**KIRKLEES METROPOLITAN COUNCIL
INVESTMENT & REGENERATION SERVICE**

DELEGATED DECISION TO DETERMINE PLANNING APPLICATIONS

Reference No:	2024/62/92983/W
Site Address:	3, Stainecross Avenue, Crosland Moor, Huddersfield, HD4 5HZ
Description:	Erection of detached garage (part retrospective)
Recommending Officer:	Joanna Rednall

DECISION – REFUSED

BLOCK PLAN.
SCALE 1:500.

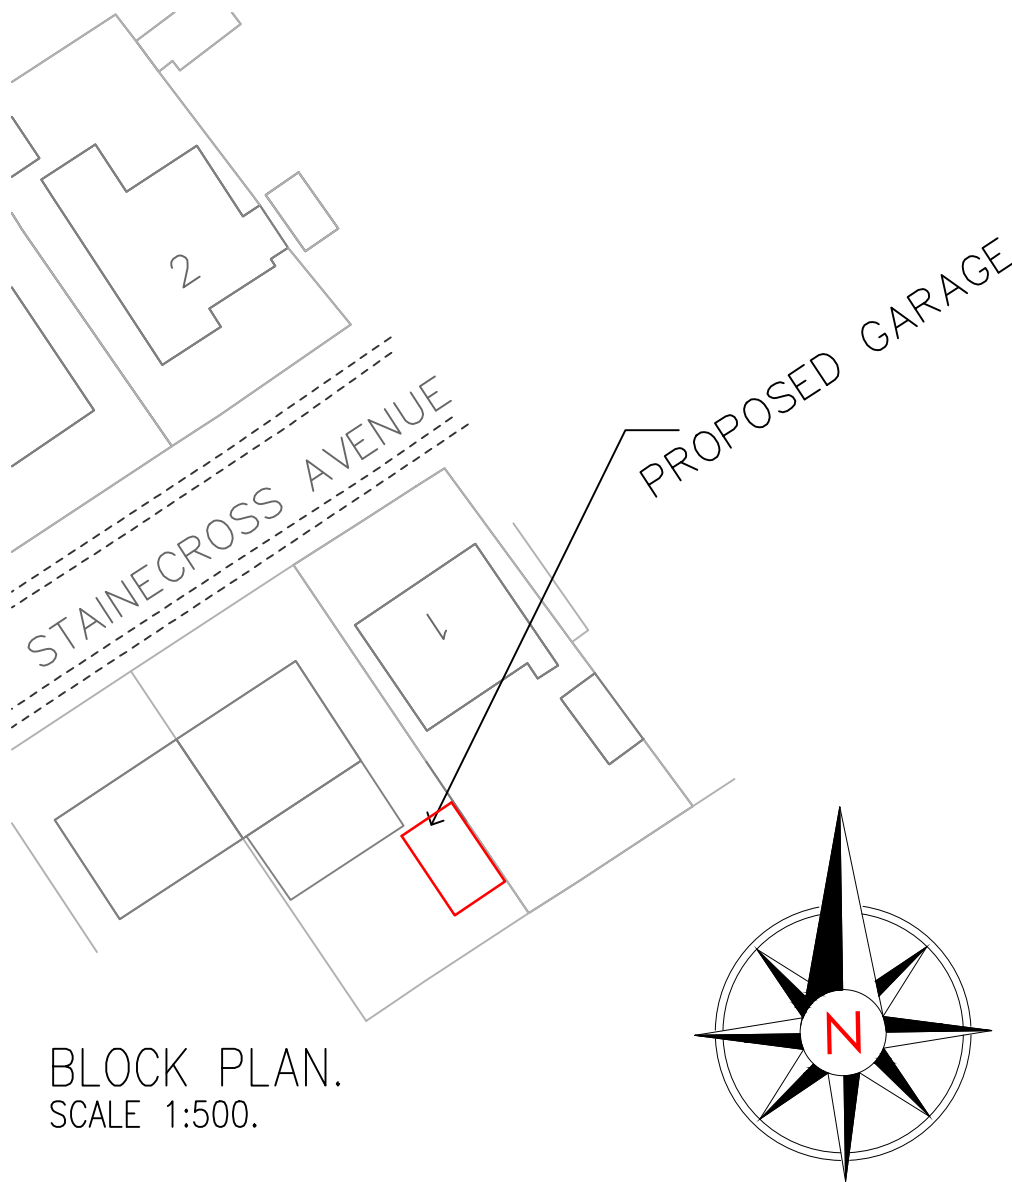
Whilst the structure would accord with the SPD to a certain extent, it is noted that the outbuilding would be sited on a significantly higher ground level than neighbouring properties to the north-east, in a prominent location adjacent to this boundary. This application does not propose changes to the siting of the garage, however the decrease in ridge height would result in the overall scale of the garage being slightly reduced. The reduction in height would assist in limiting the visual impact on the original house and street scene and would reduce the detrimental bulking and massing impact of the development when viewed from wider public vantage points and within the context of the site. The reduced height would appear proportionate to the application property and would not over-dominate the site.

In regard to overbearing, it has been assessed that the development would intensify development to the north-east of the application site and create significant bulk and massing along the shared boundary. Although the garage would be reduced in height (approximately 0.6 metres) from the previous application, this is not considered to overcome the overbearing and oppressive concerns of the garage on No.1. This is because the extent of bulking and massing as a result of the side wall would remain along the shared boundary. The overbearing effects are intensified as a result in the elevated ground level of the application site, and the reduction in ridge height is not considered sufficient to overcome the harm.

In regard to overbearing and overshadowing, the garage is set off the shared boundary by approx. 9 metres. Given this separation distance, it is considered sufficient to prevent undue impacts of overbearing/overshadowing.

PROPOSED GARAGE PLAN.
SCALE 1:50.

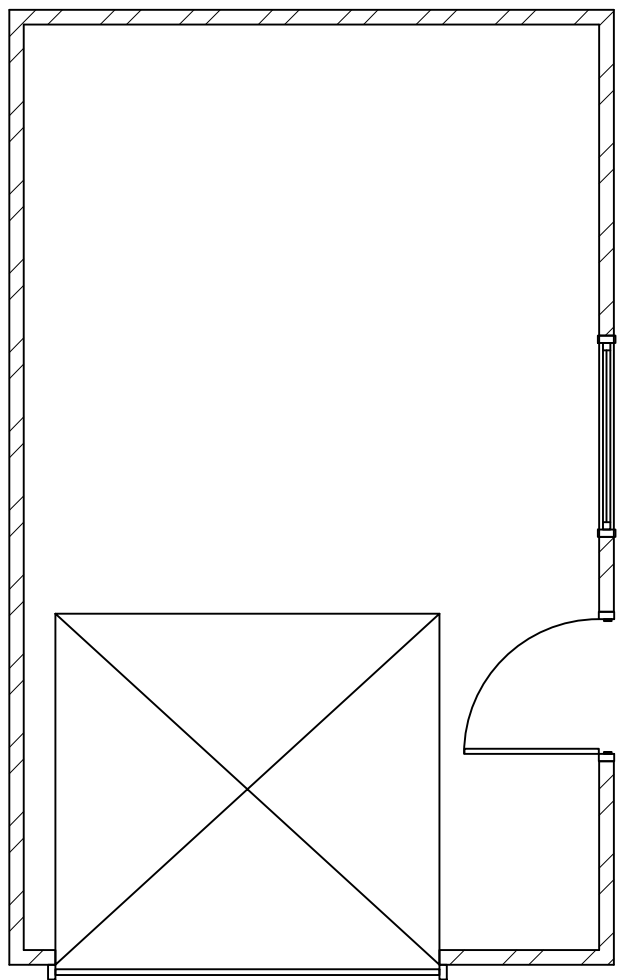
The detached garage is located within the rear curtilage of the dwellinghouse with a width of approximately 4 metres, a depth of 6.3 metres and a ridge height of 3.6 metres. As set out in the Design and Access Statement, the garage has been reduced in height where the ridge has been lowered approximately 0.6 metres to try to overcome the previous reasons for refusal (application ref: 2024/91678) with regard to visual amenity. It is also noted that a previous garage of smaller dimensions sited to the rear of No.3 has also been approved under application 2019/93655.

The detached garage is located along the boundary with a depth of 6.3 metres, eave height of 2.6 metres and ridge height of 3.6 metres when measured from the ground level of the application property. Given the difference in ground levels, the detached garage is elevated above what appears to be the main amenity space of this neighbouring dwelling.

PROPOSED FRONT ELEVATION.
SCALE 1:100.

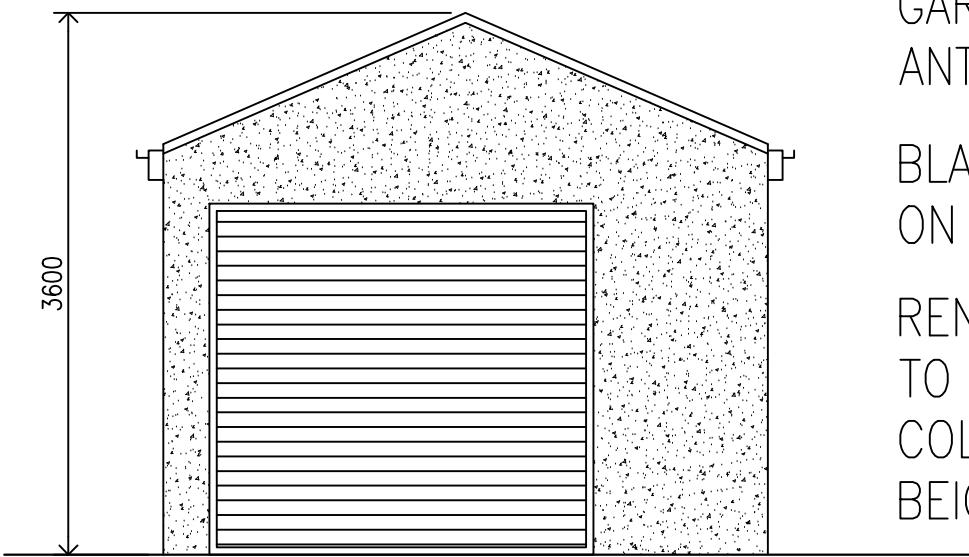
With regard to fenestration, the proposed plans show the level of glazing from the previous application would be reduced with only a door and pair of windows to the side/ south-west elevation. The roller shutter garage door would be of anthracite grey colour finish. These details are considered to be in keeping with the host property and would have an acceptable visual impact. Whilst the siting remains, it is considered that coupled with the alterations to the scale of the building and materials of construction, on balance, the visual impact of the proposal overcomes the previous reason relating to visual impact.

PROPOSED SIDE ELEVATION.
SCALE 1:100.

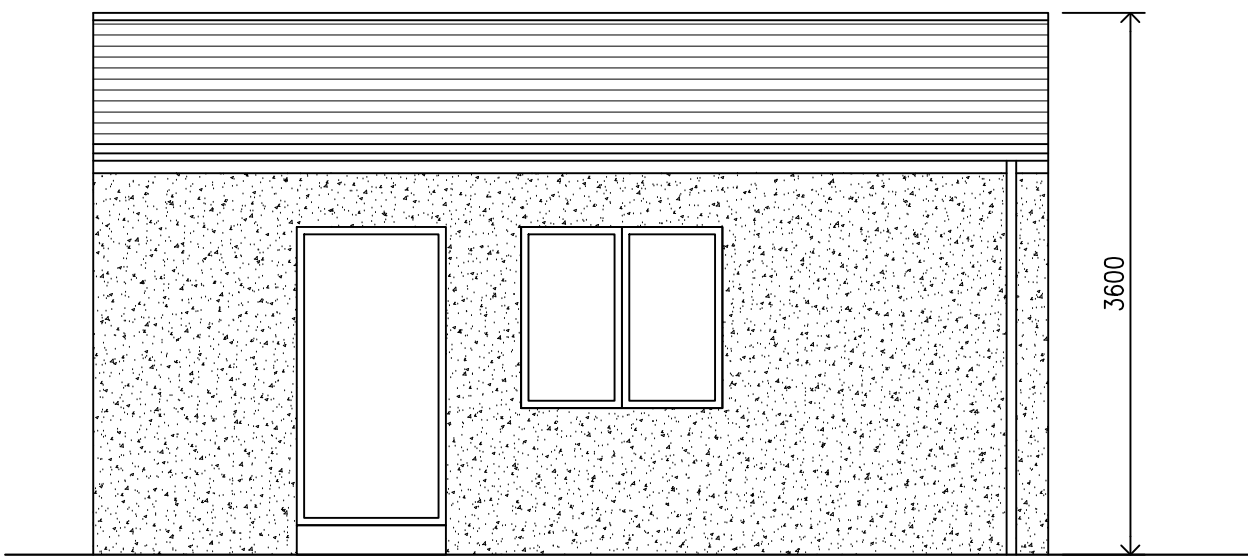
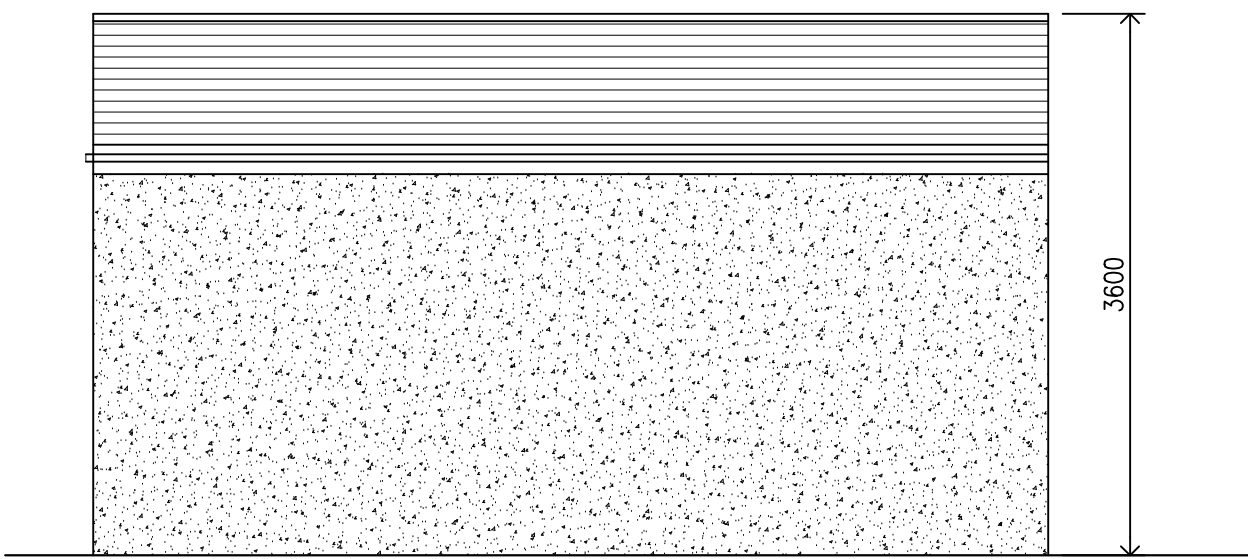
The submitted plans show the garage would be finished in beige colour render. This finish would be a visual improvement to the existing appearance and materials, which consist of stone to the front, side (south-west facing) and rear elevations and concrete blocks to the other side (north-east facing) elevations. This finish would form a more cohesive appearance with the host property and would be in keeping with the material palette of the locality.

In regard to overshadowing, these neighbours are located to the north-east of the application site and therefore any impact would only be visual within an evening. For these reasons any harm on overshadowing can be supported. Alongside this, the submitted plans show no additional openings to be inserted into the north-east facing side elevation which will ensure no undue harm as a result of overlooking.

With regards to overlooking/ privacy, the proposed plans show two openings inserted to the side/ southwest facing elevation in the form of a door and a window. The garage is situated at the opposite side of the dwellinghouse and away from these neighbours and is not a habitable building. As such there will be no further impact on these neighbours' amenity in regard to overbearing, overshadowing and overlooking.
